From: Anita Gardner
Sent: 12 July 2018 11:35
To: Karen Parsons
Subject: FW: FG/75/18/HH - Side dormer, Everglades, Florida Road, Ferring

Side Dormer, Everglades, Florida Rd, Ferring
FG/75/18/HH

block plan and sheets 2-4. In order for this clarification to be confirmed and recorded I would appreciate your agreement to an extension of time on the application until 16-07-2108.

Block Plan

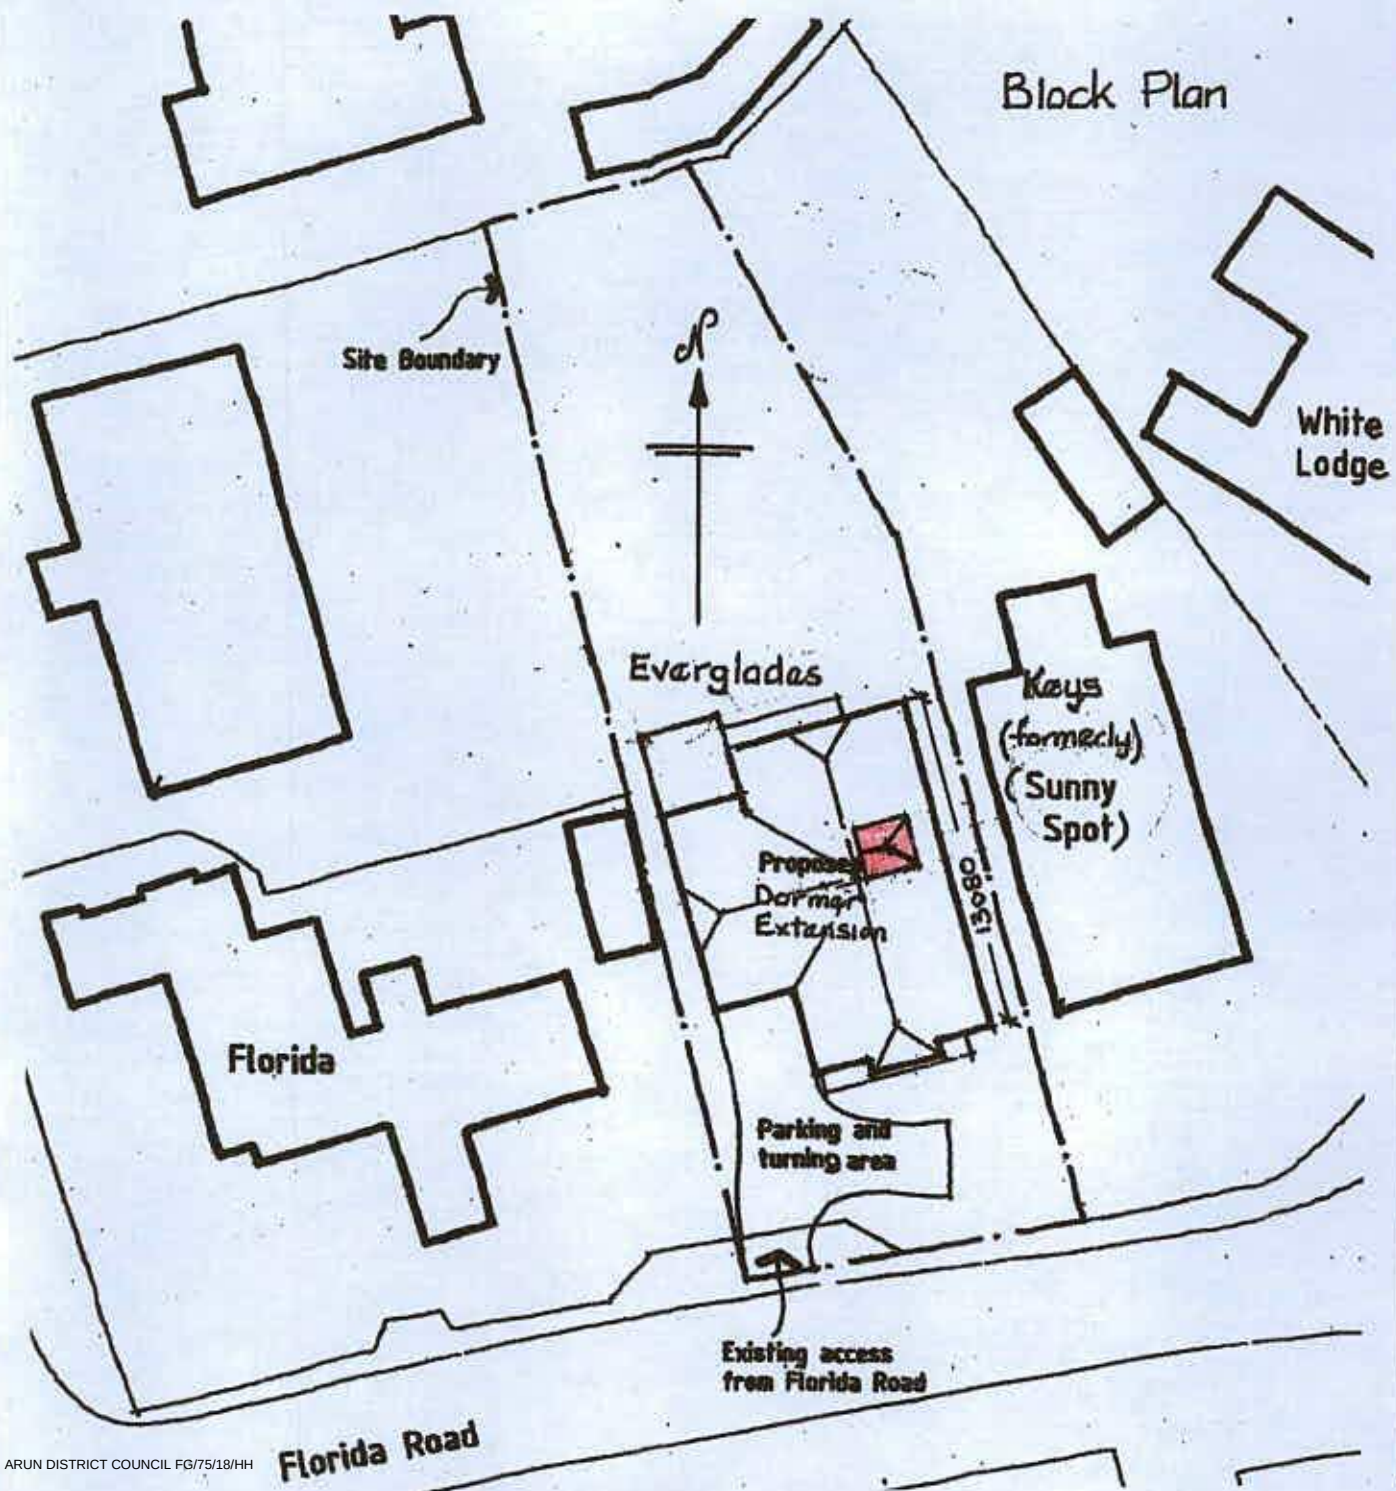
I am the case officer dealing with the above application. I note that with the exception of the Location Plan, Layout and Cross Section, the plans do not have scales. Please can you confirm the scale of the

The Block Plan and the Elevations in drawings 2 – 4 were obtained from microfiche records of the original approved house construction plans held at Littlehampton Council.

Block Plan : 1 in 300
